ADDENDUM

Project: Science Building Research Wing Expansion

Project No. 03049

Addendum: No. 1

ALTERNATE #5
3 SECOND FLOOR PART PLAN - RENOVATION
W2.1 1/8" = 1'-0"

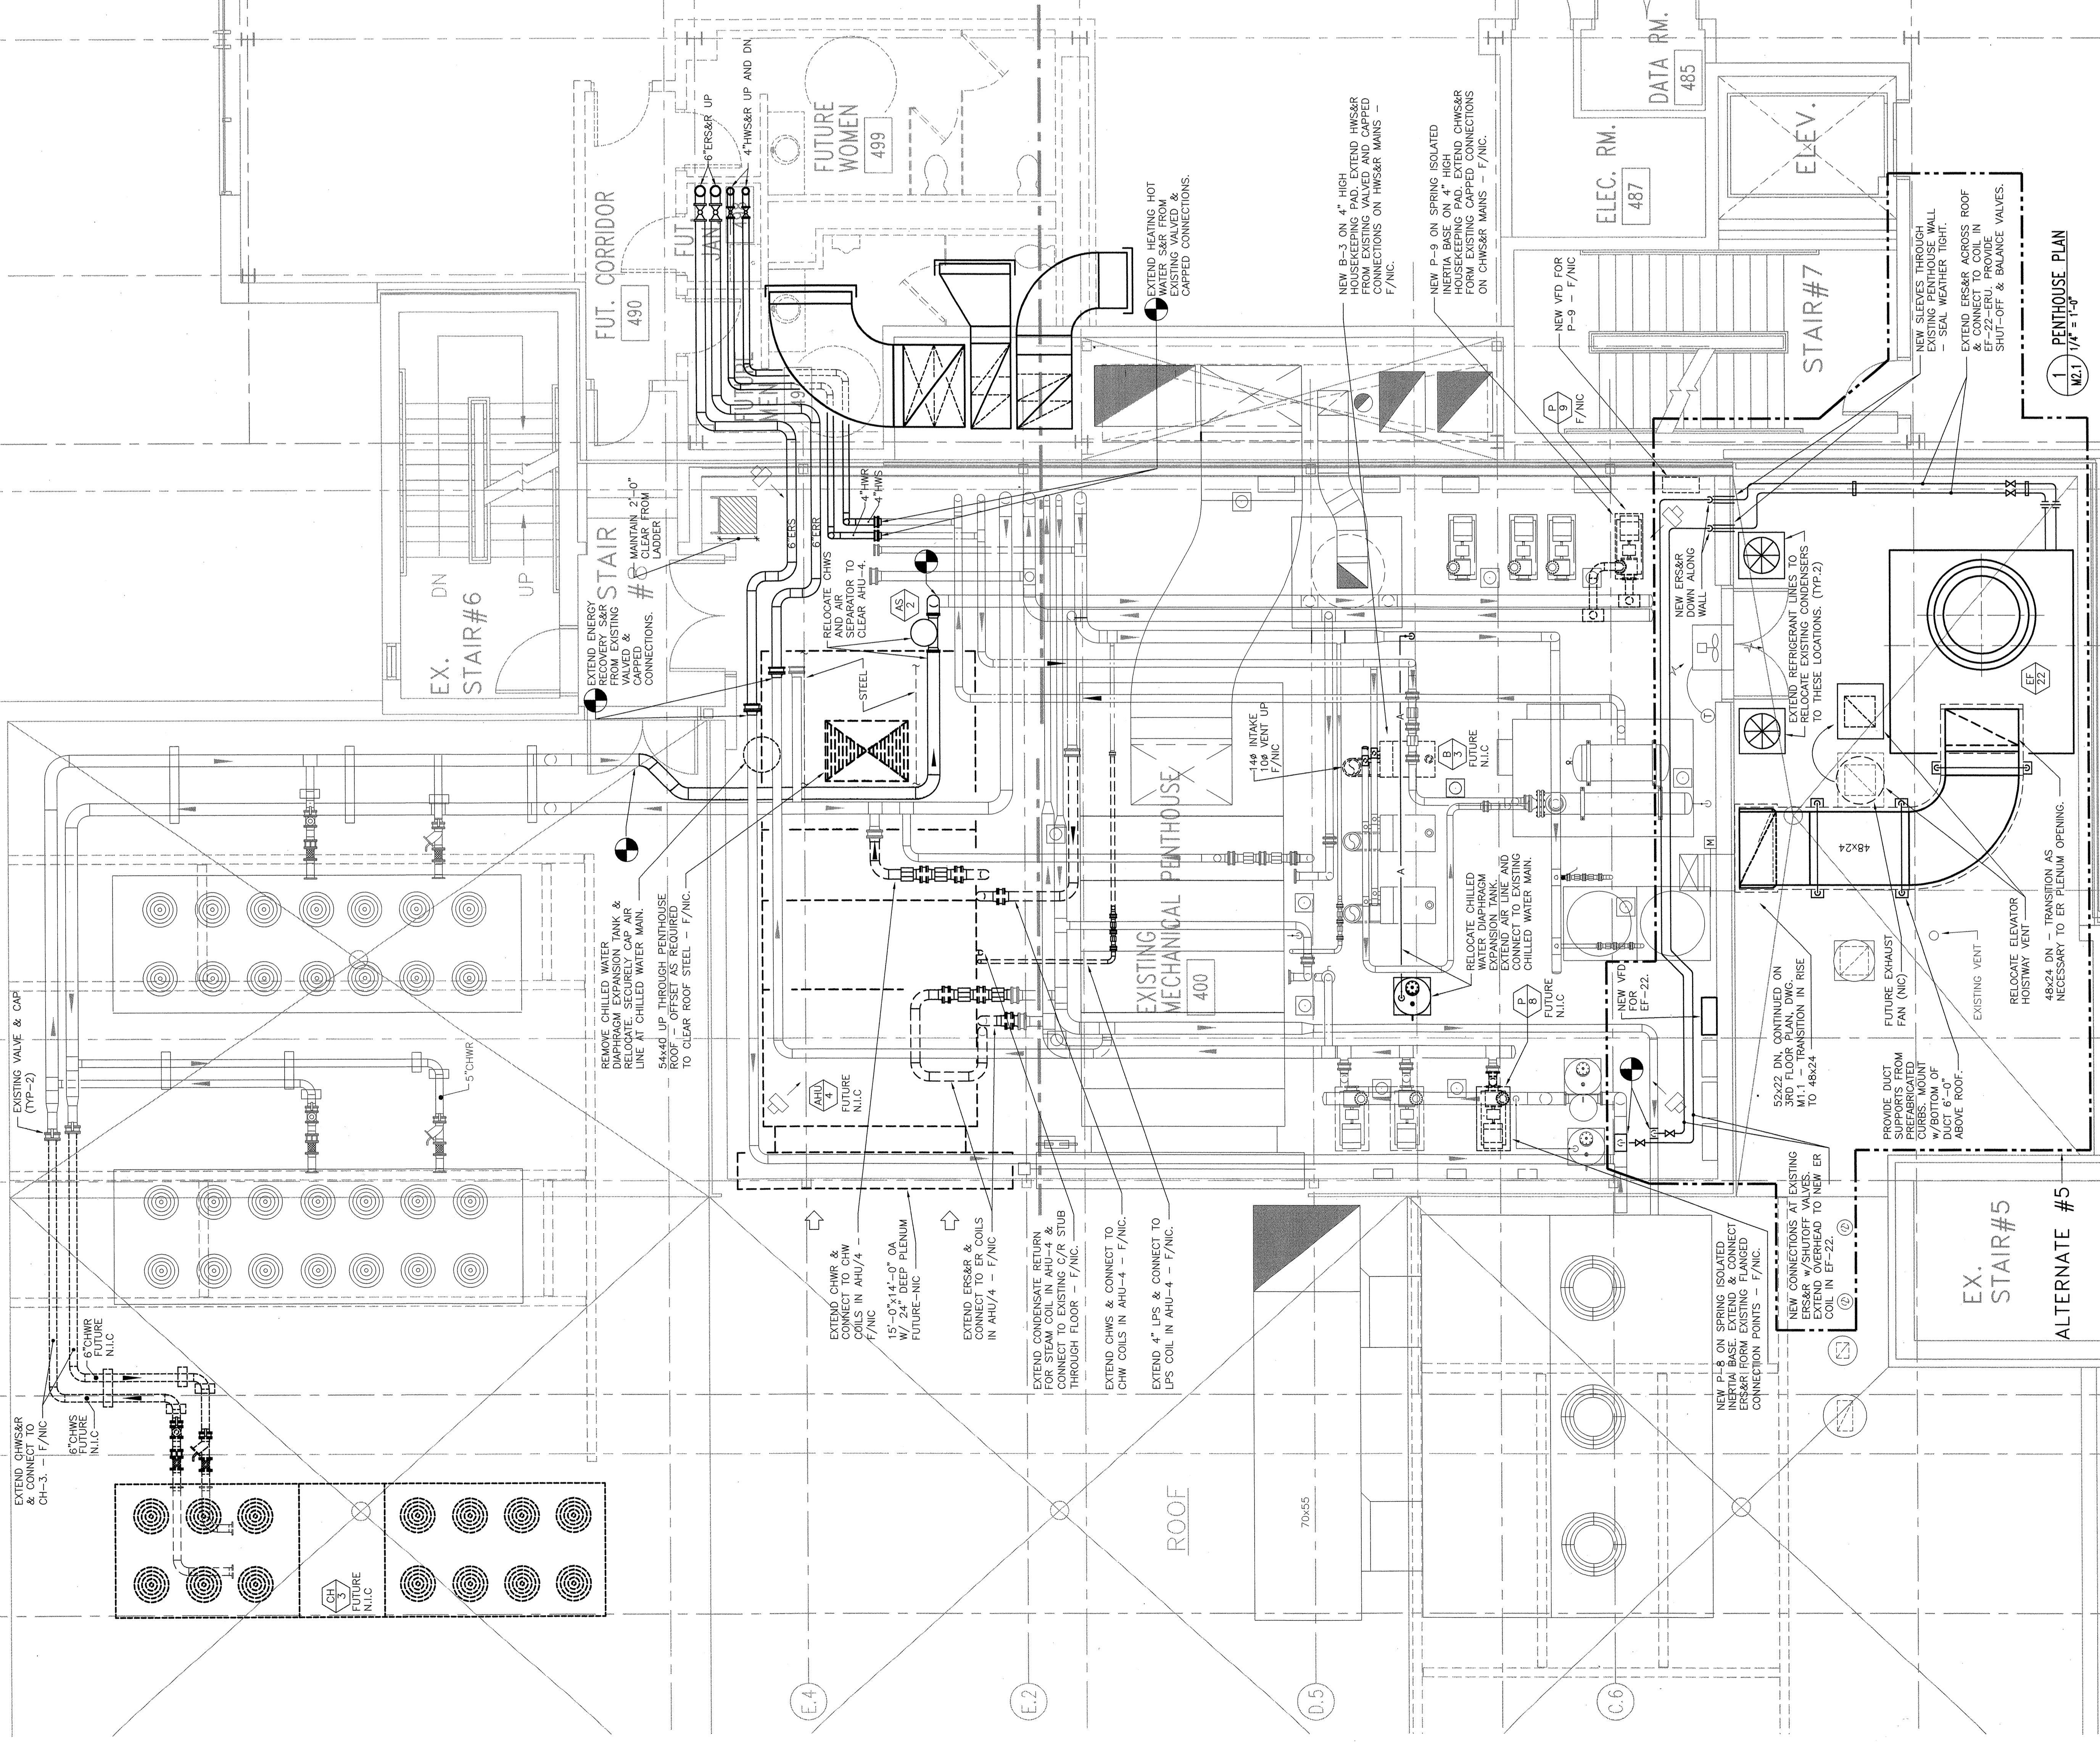
M2.1 Second Floor and Penthouse Plans

1. Change note at EF/22 to read "Extend 4" ERS7R across roof I connect to coil in EF-22-ERU. Provide shut-off and balance valves."

ALTERNATE #4
CHILLED WATER CONNECTION DETAIL
SCALE: NONE
W2.2

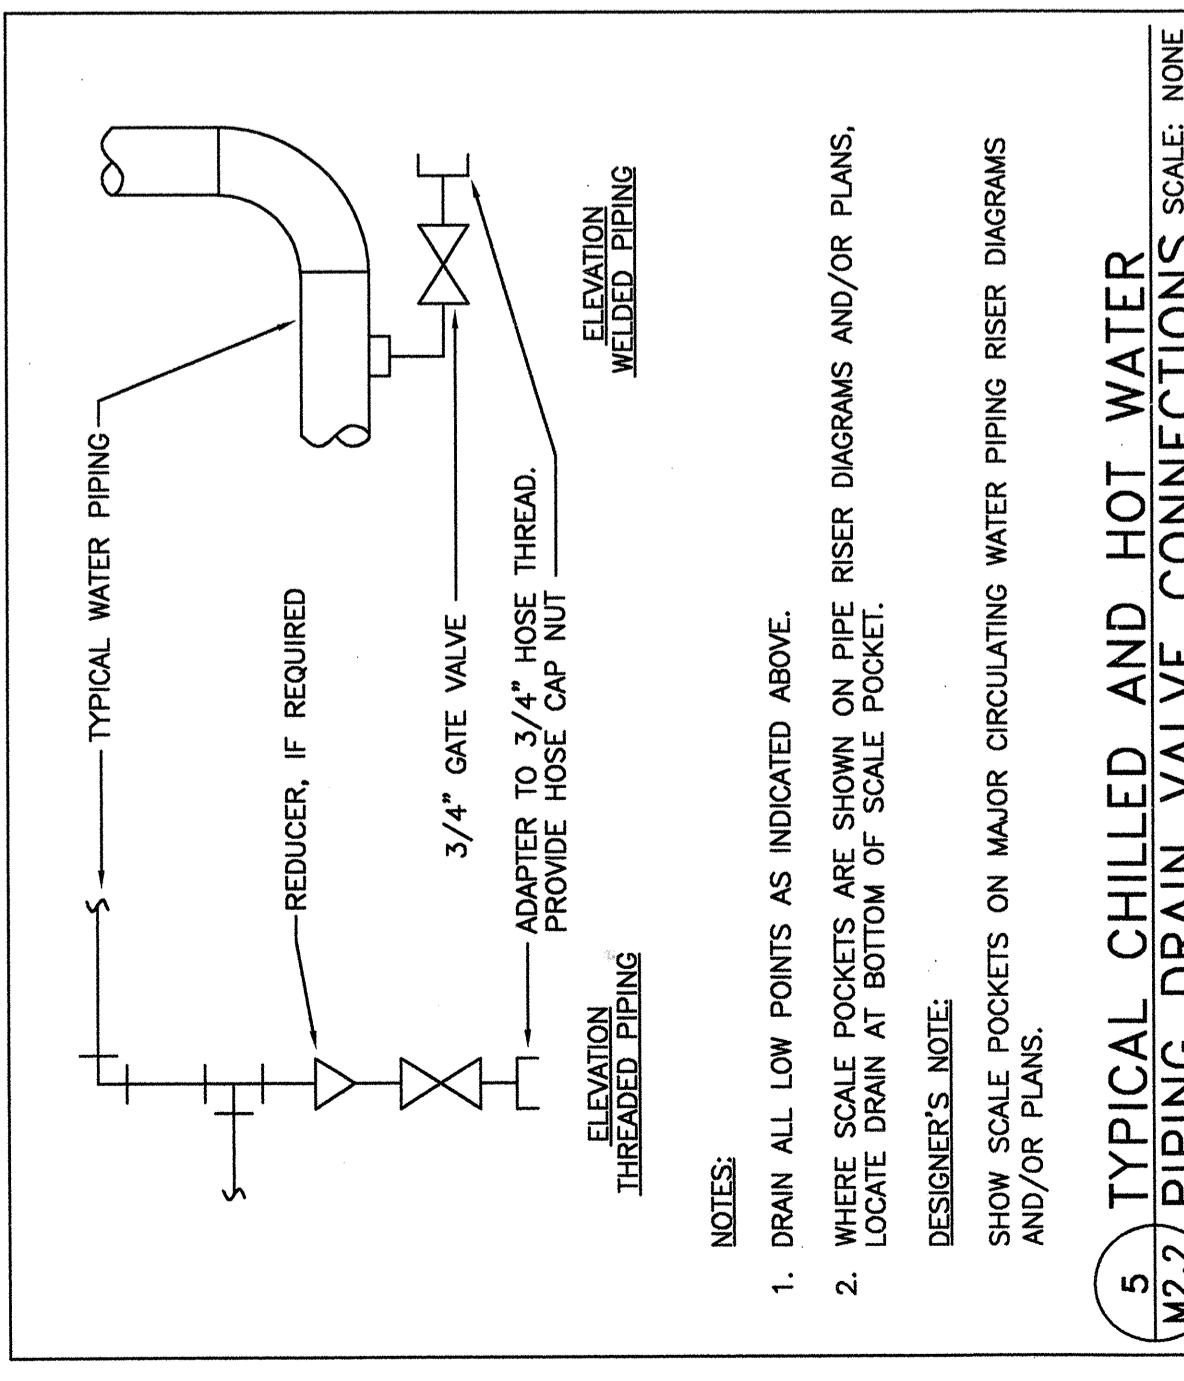
M2.2 Part Plans, Section and Details

1. Refer to Detail 4/M2.2. Change note to read "Extend 1" chilled water horizontally for cross connection to Science Wing CHWS&R."

NEW FOURTH FLOOR FRAMING PLAN

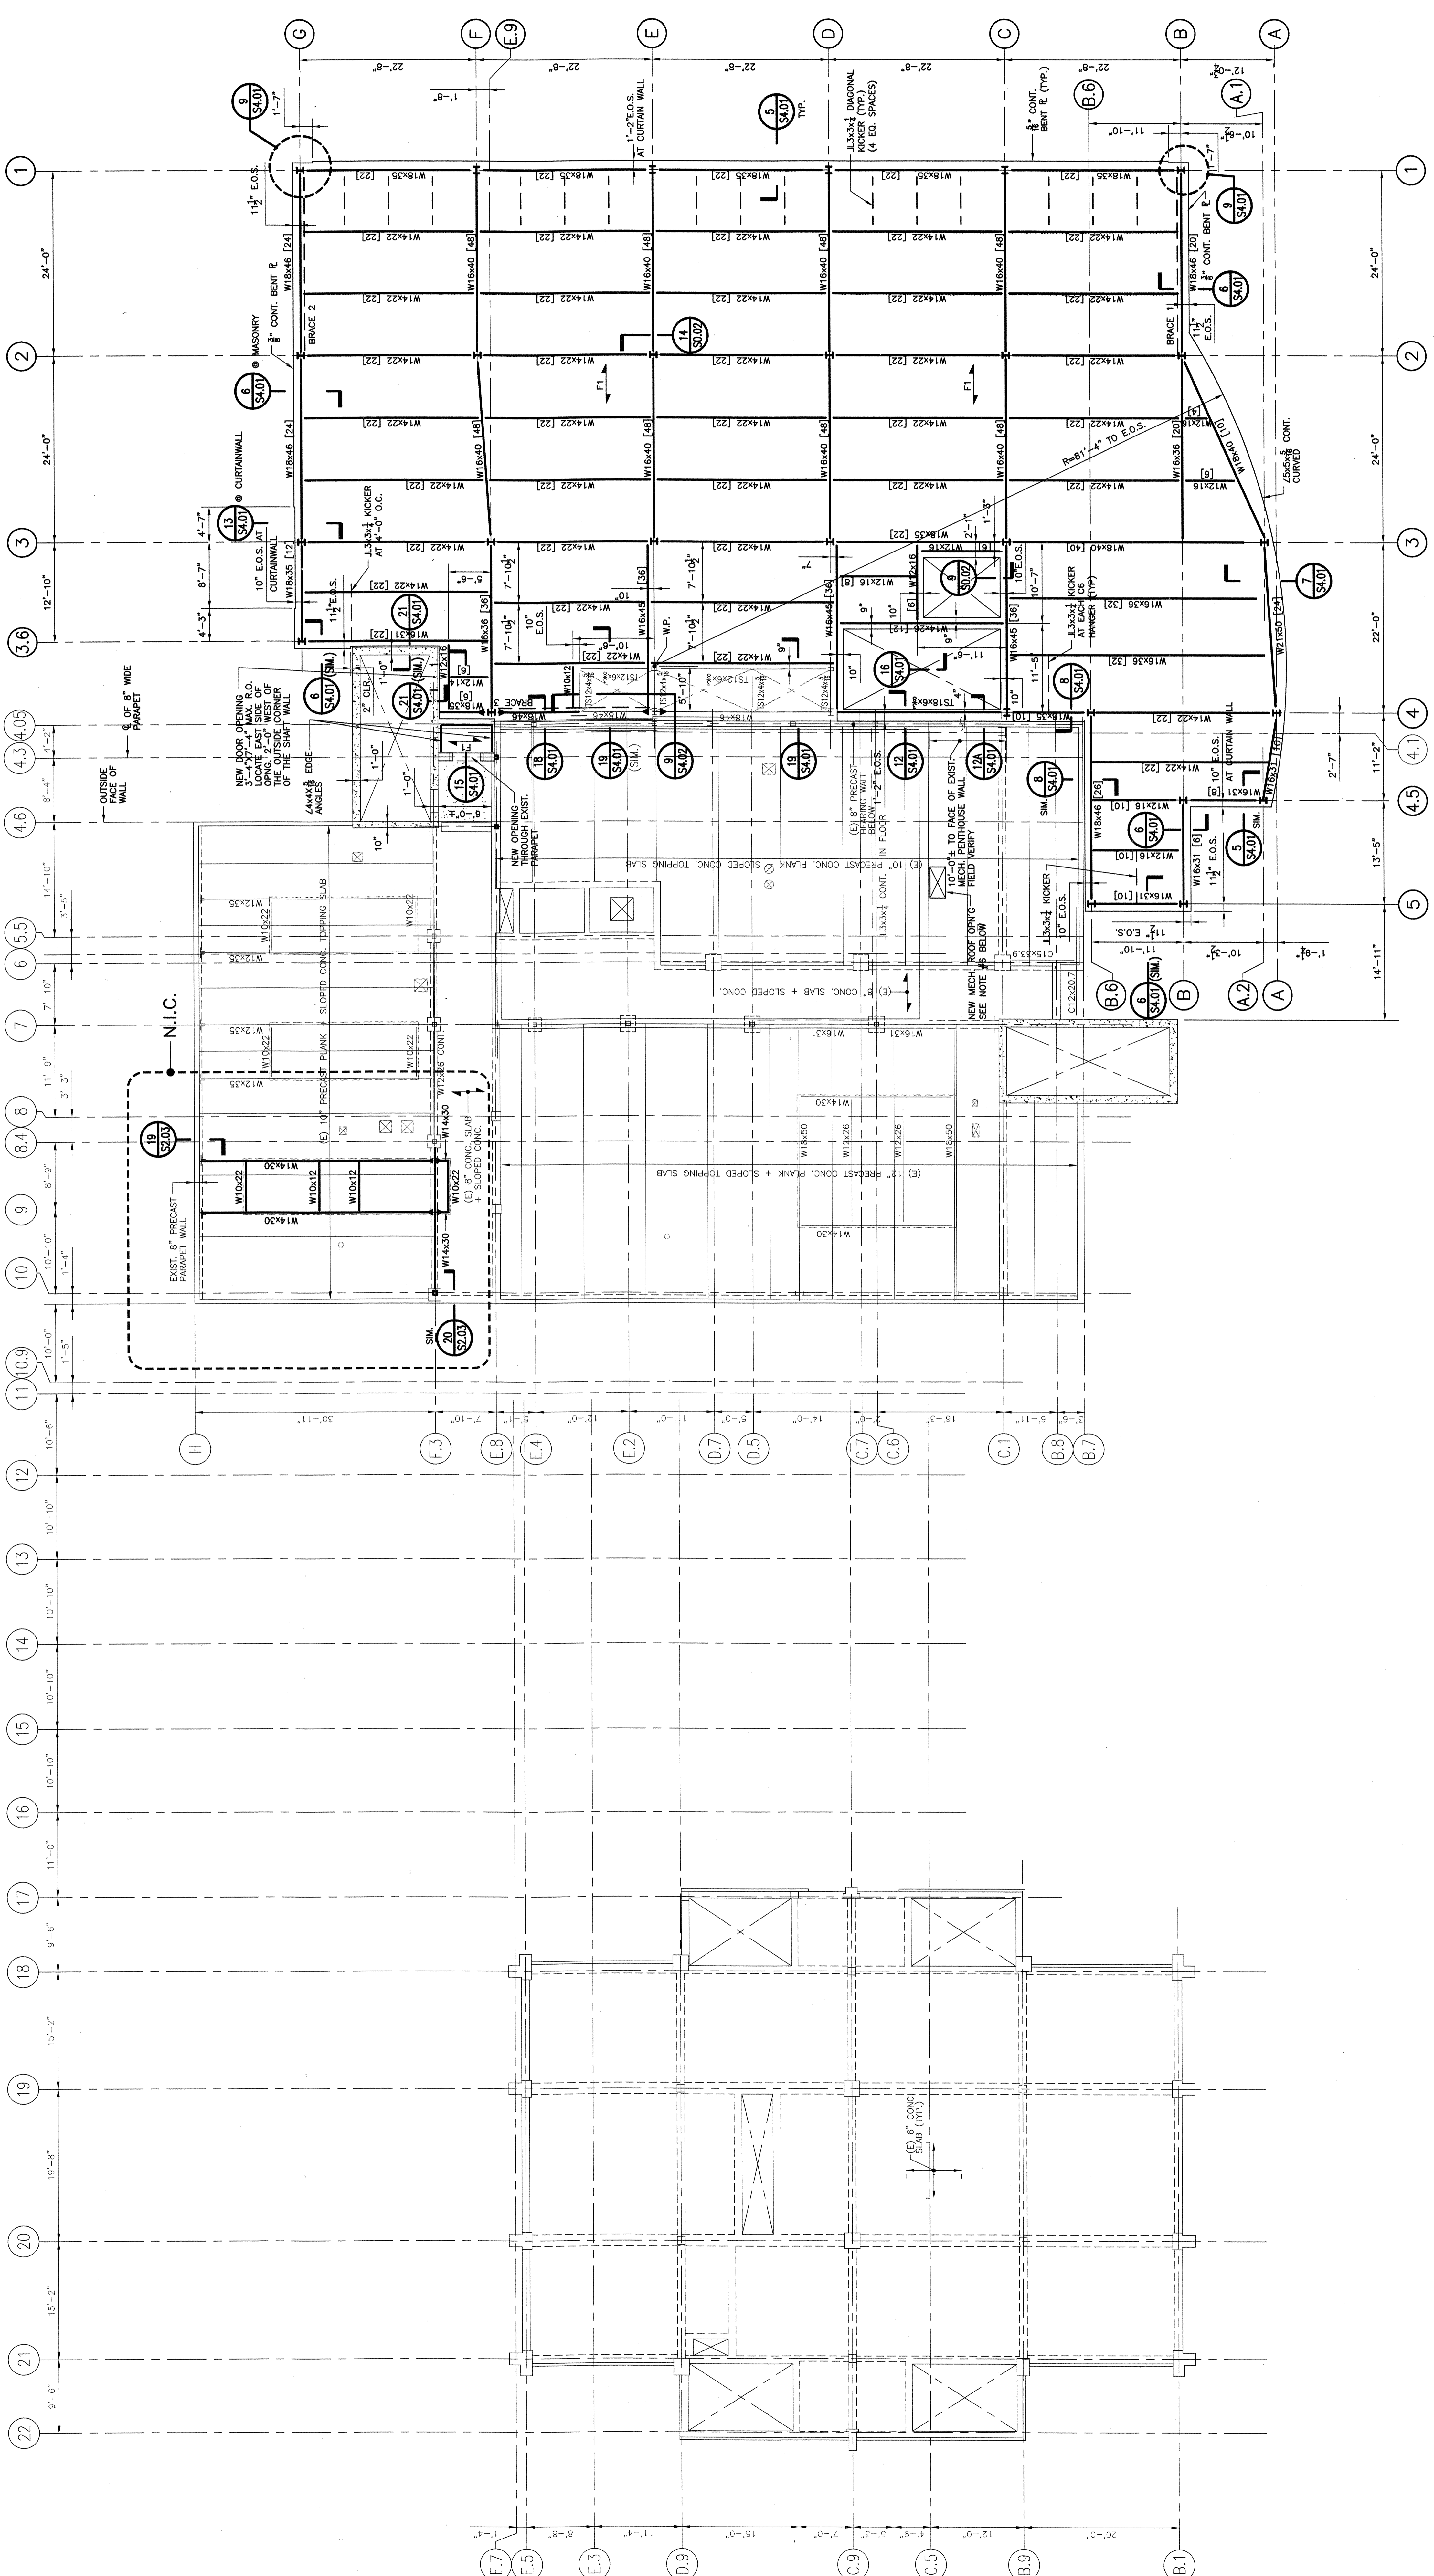
S1.41, New Fourth Floor Framing Plan

1. Revise mechanical shaft dimensions and remove existing steel girts as shown on sketch ADD-1/SKS-2.
2. Omit sawcut opening note at section 15/S4.01 in the area of gridline 4.3 and F. Locate the opening in the same area on the third floor. Refer to the architectural drawings for size and location.
